Response to Kildare County Council
Pre-Application Consultation Meeting Comments
& Discussions Relating to Hospital Street

Magee Barracks, Hospital Street, Kildare Town

This report has been prepared to address the items noted by and received from Kildare County Council in relation to Drainage for the Residential and Neighborhood Centre Development (Phase 1) on the Former Magee Barracks Site in Kildare Town, County Kildare. Garland met with KCC WSD Senior Executive Engineer, Mr David Hall, on 10 January 2019 in order to discuss his queries in detail.

Drawing file: Engineering / R1831-1000C Phase 1 Overall Site Foul Sewer Strategy Layout.pdf

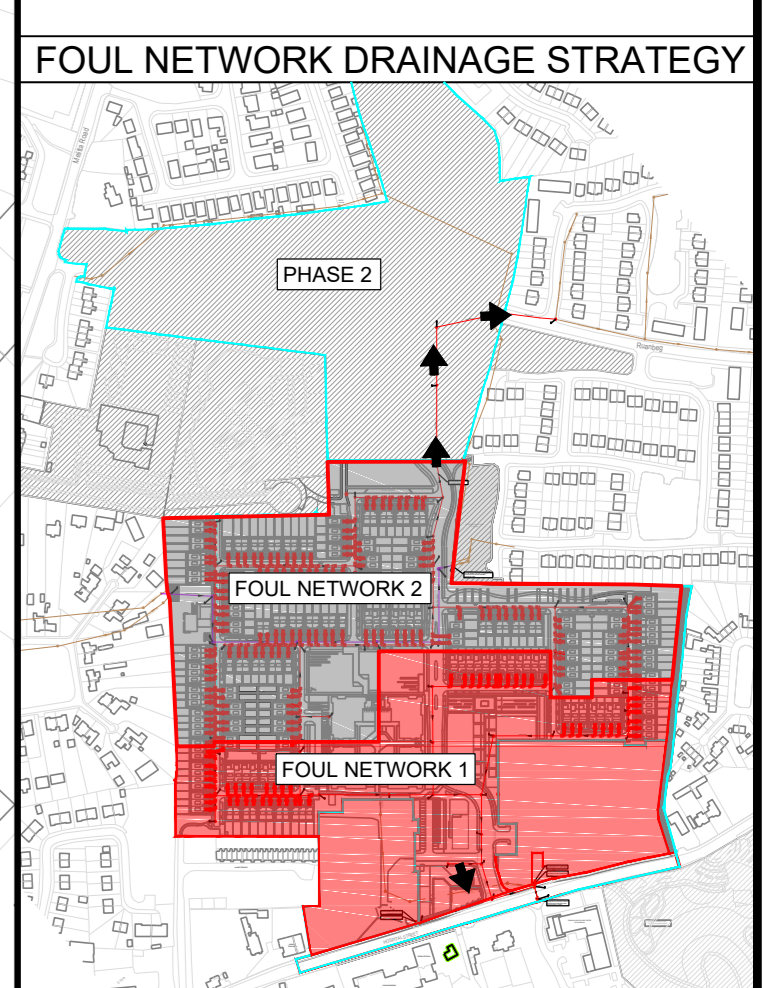
1.4	LA WSD not in favour of foul sewer discharge to the existing 600mm dia sewer traversing through Ruanbeg and proceeds under the former Chapmans Garage building to connect to the sewer main on Curragh Road.	The proposed development will be divided into 2 distinct drainage catchments, North and South. The northern catchment drainage strategy has been revised to discharge to the existing foul sewer network within Ruanbeg Crescent (previously Ruanbeg Drive). This network connects to the sewer main on Curragh Road, and completely negates the issue of discharging to the sewer main running underneath the former Chapman's Garage.

Drawing file: Engineering / R1831-1009B Phase 1 Foul Sewer 600mm dia and 2No 50mm Dia Rising Main Diversions Layout.pdf

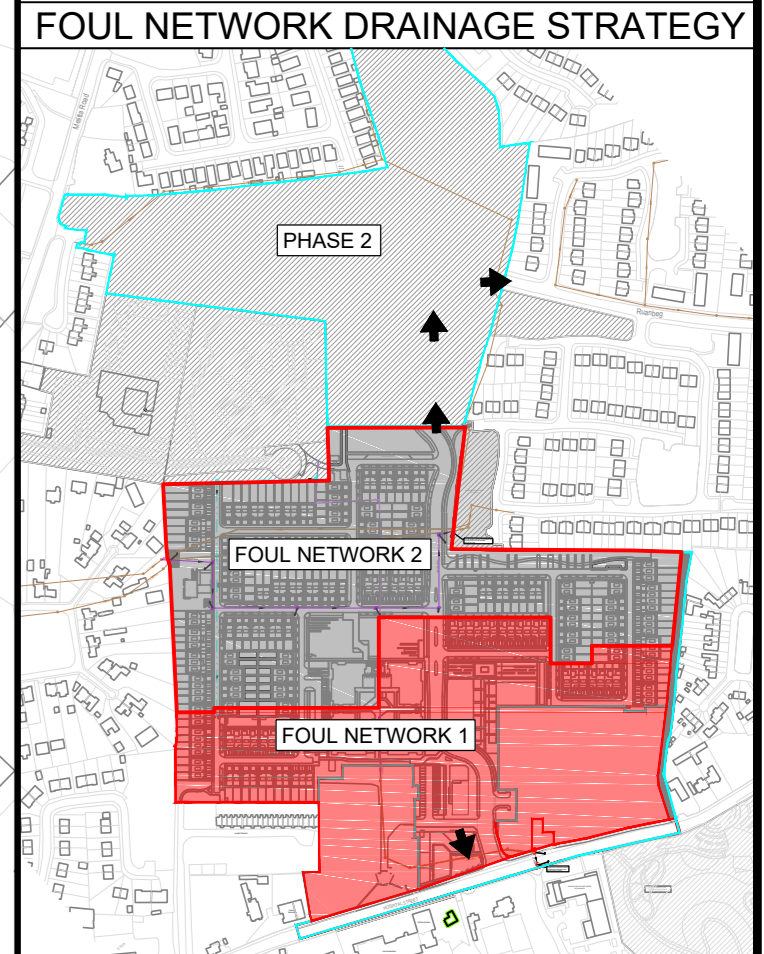
1.6	LA WSD recommends all sewer diversions should be designed and provided with adequate capacity and wayleave.	The housing layout (in the vicinity of Coolmoney Square) has been revised to address the concern in relation to sufficient wayleave widths. The new layout also assists in ensuring the diversion angles are sufficient to promote flow and decrease risk of friction losses and restrictions. Garland confirms that the design proposal of replacing the existing 2 no foul mains (300mm dia and 375mm dia) with 1 no 600mm dia has sufficient capacity to convey the existing flows within these existing foul mains.

LONGSECTION F MH1 TO EX F MH1
FROM 0.000 TO 418.064

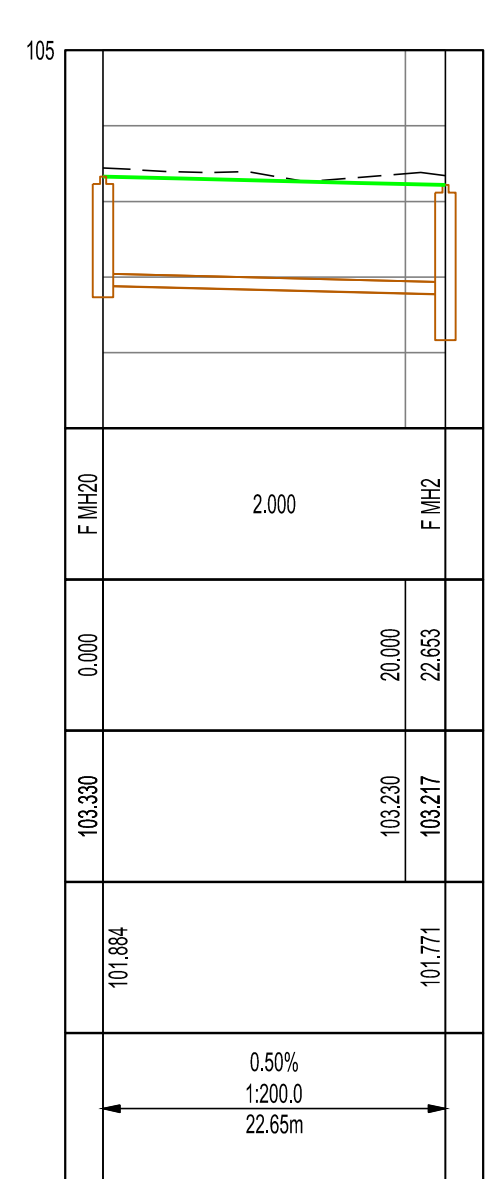
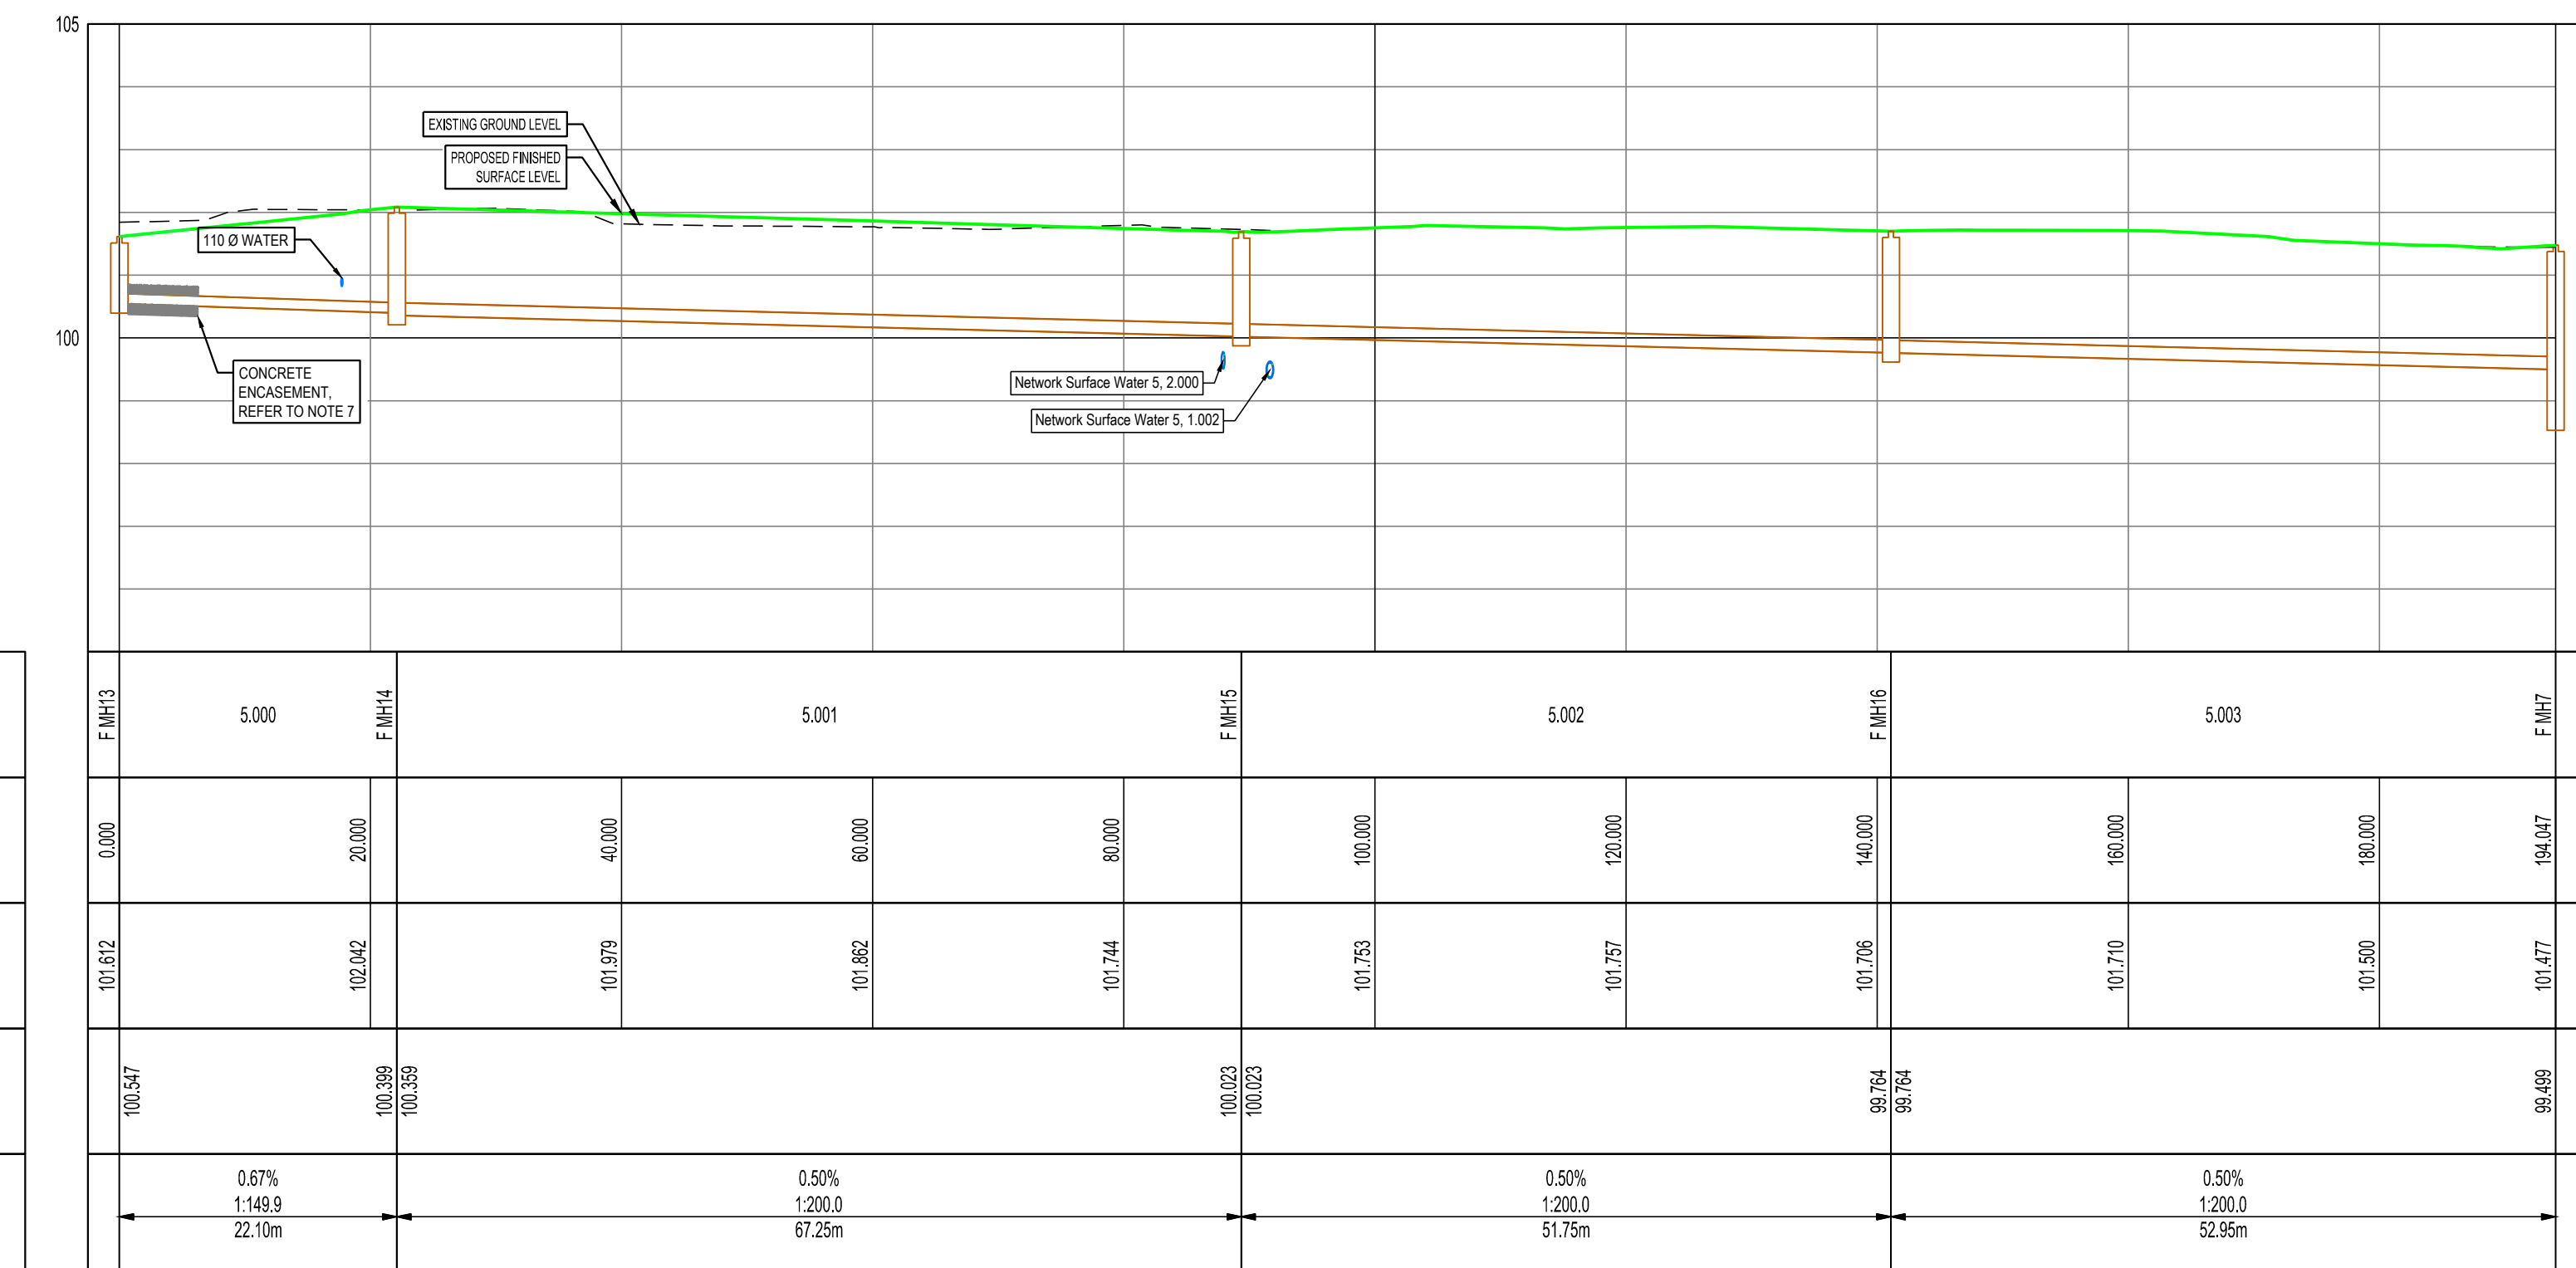
calculations should be clearly indicated on the drainage layout drawings.	
1.12	Detailed foul drainage longitudinal sections submitted with the planning application should show the intersection points with other services particularly the surface water sewers.	Garland confirms that foul drainage longitudinal sections shows the intersection points with other services.
